PROJECT NAME: **Tamarack Valley Rezone (RZ-10-04) & Preliminary Plat (LP-10-03)**

STAFF REPORT TAMARACK VALLEY REZONE & PRELIMINARY PLAT

TO: Kittitas County Hearing Examiner
FROM: Kittitas County Community Development Services Staff
RE: Tamarack Valley Rezone (RZ-10-00004) and Preliminary Plat (LP-10-00003)
DATE: May 26, 2011 Hearing

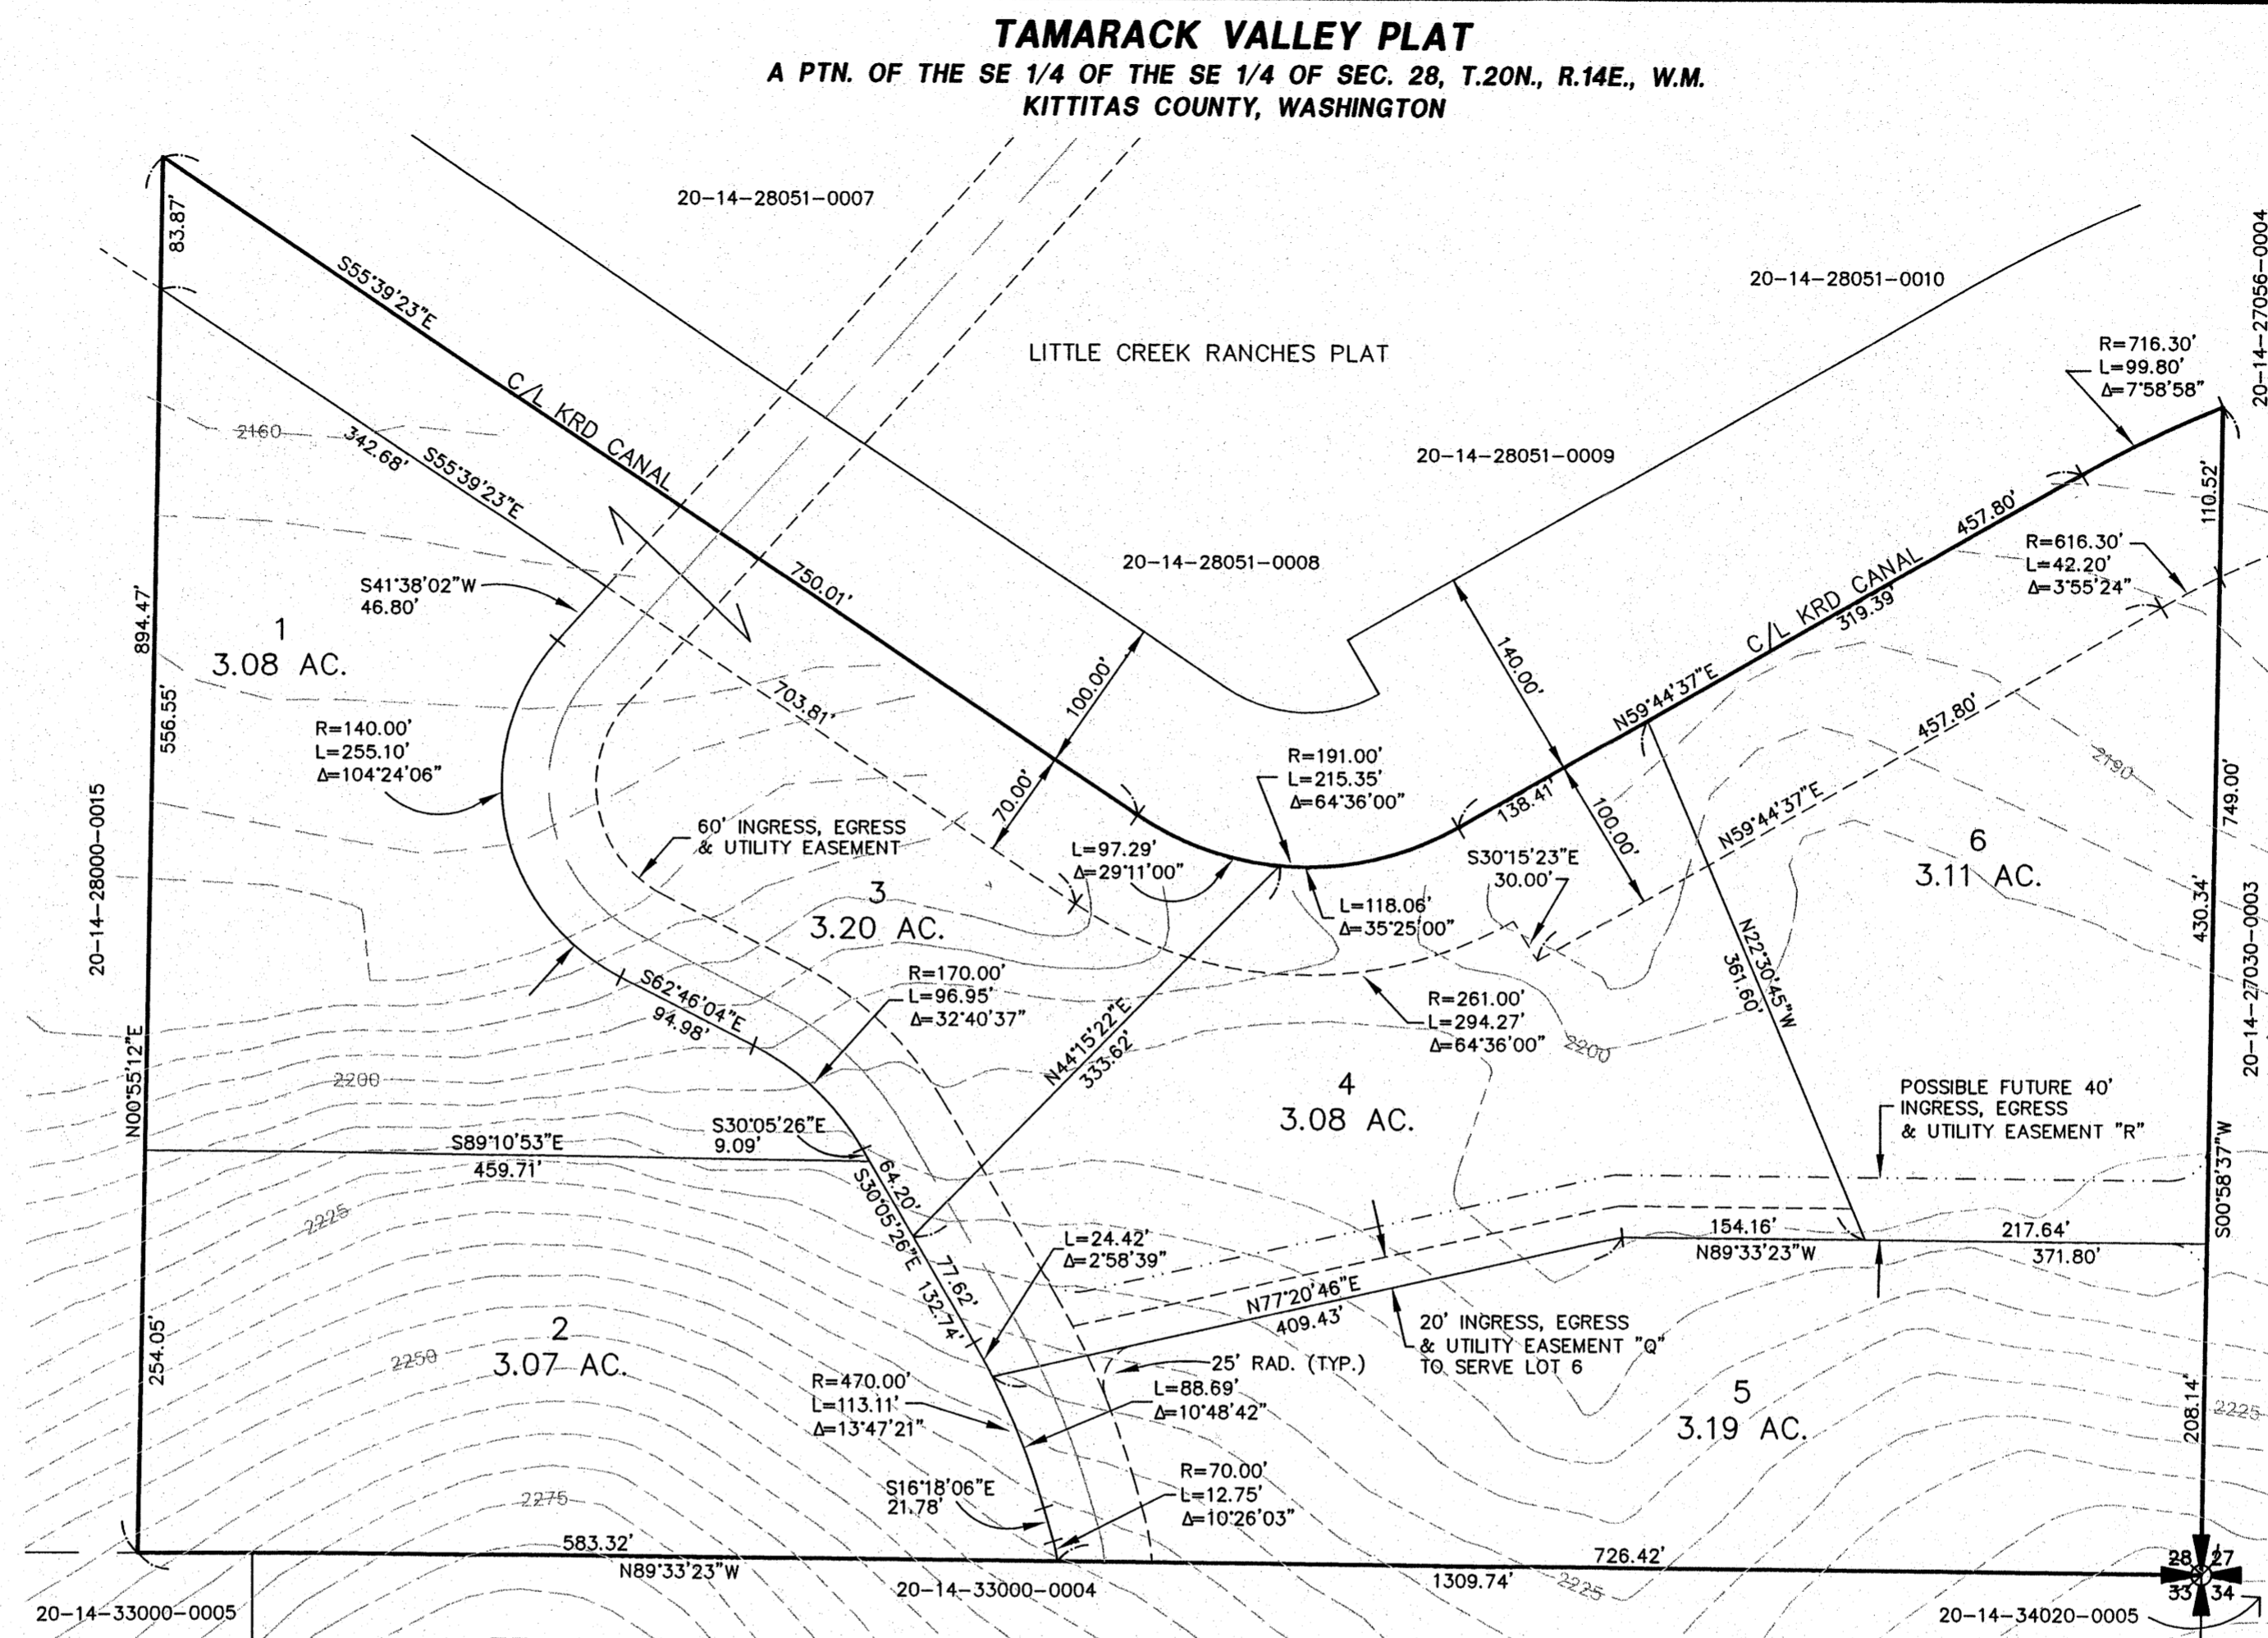
8. The KRD canal easement line at the northern end of Lot 1 is shown as a solid line, but it should be a dashed line. Solid lines indicate lot lines; however, the northern lot line of Lot 1 is the centerline of the

KRD Canal. The final plat shall show the KRD easement line on Lot 1 as a dashed line, consistent with other easements on the plat.
